CITY OF ALBUQUERQUE

August 23, 2022

RE: **Lot 6 Block 1 Volcano Cliffs Unit 22 SAD 228**
8019 Alto Rey Ct. NW
Grading and Drainage Plan
Engineers Stamp Date 7/23/2020 (D10D003N6)
Pad Certification Date 8/19/2022

ENGINEER'S SEAL DAVID SOULE P.E. #14522	LOT 6 BLK 1 UN 22 VC 8019 ALTO REY CT.	DRAWN BY DEM
	GRADING AND DRAINAGE PLAN	DATE 7-23-20
	 1606 CENTRAL AVENUE SE SUITE 201 ALBUQUERQUE, NM 87106 (505) 872-0999	LOT XX BLK 1 UN 22 VC.DWG SHEET # C1 JOB #

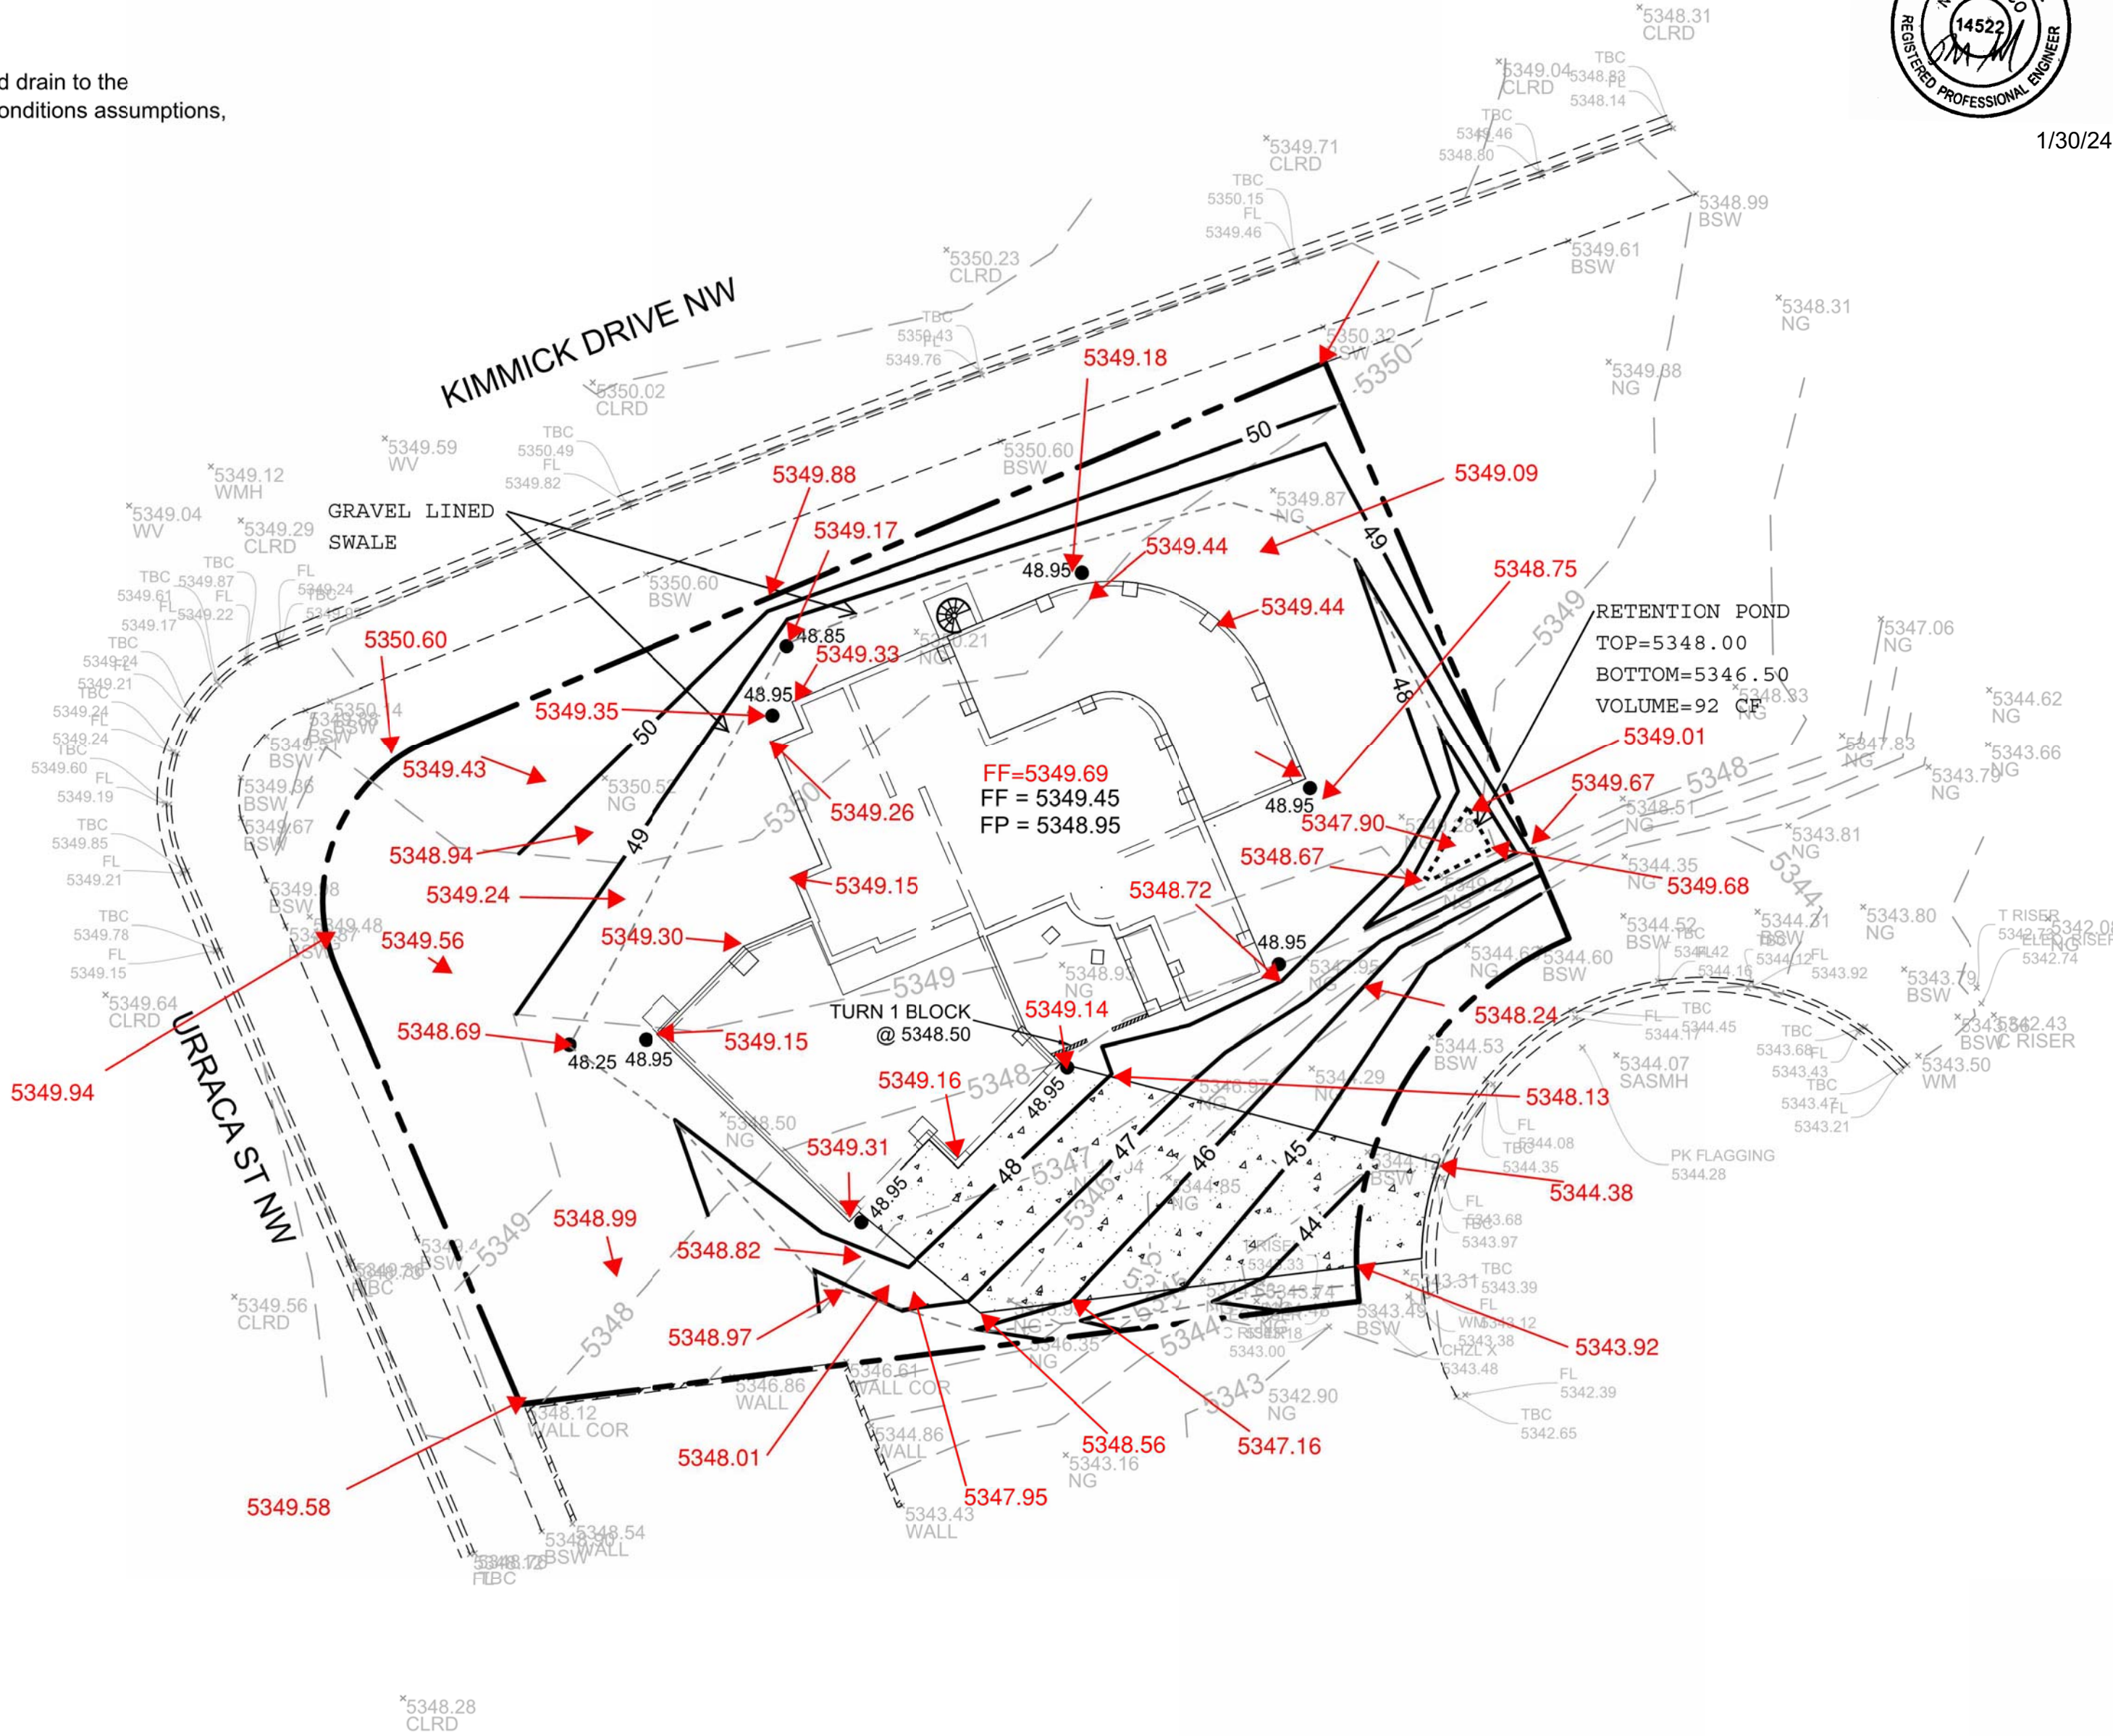
- The building pad is 4 feet to high. I believe this was addressed at grading permit. It is not allowed for a retaining wall of this height to be in the front yard. A complaint was issued on this property several months ago.

Reiterate to the Owner/Contractor that a separate permit for a garden/retaining wall must be obtained, with the approved G&D plan and Pad Certification. Advise the owner & Contractor that dirt is not allowed in the public right of way to climb the curb. Crusher fines or lumber is allowed. If dirt is used this will delay going forward with the construction of the home.
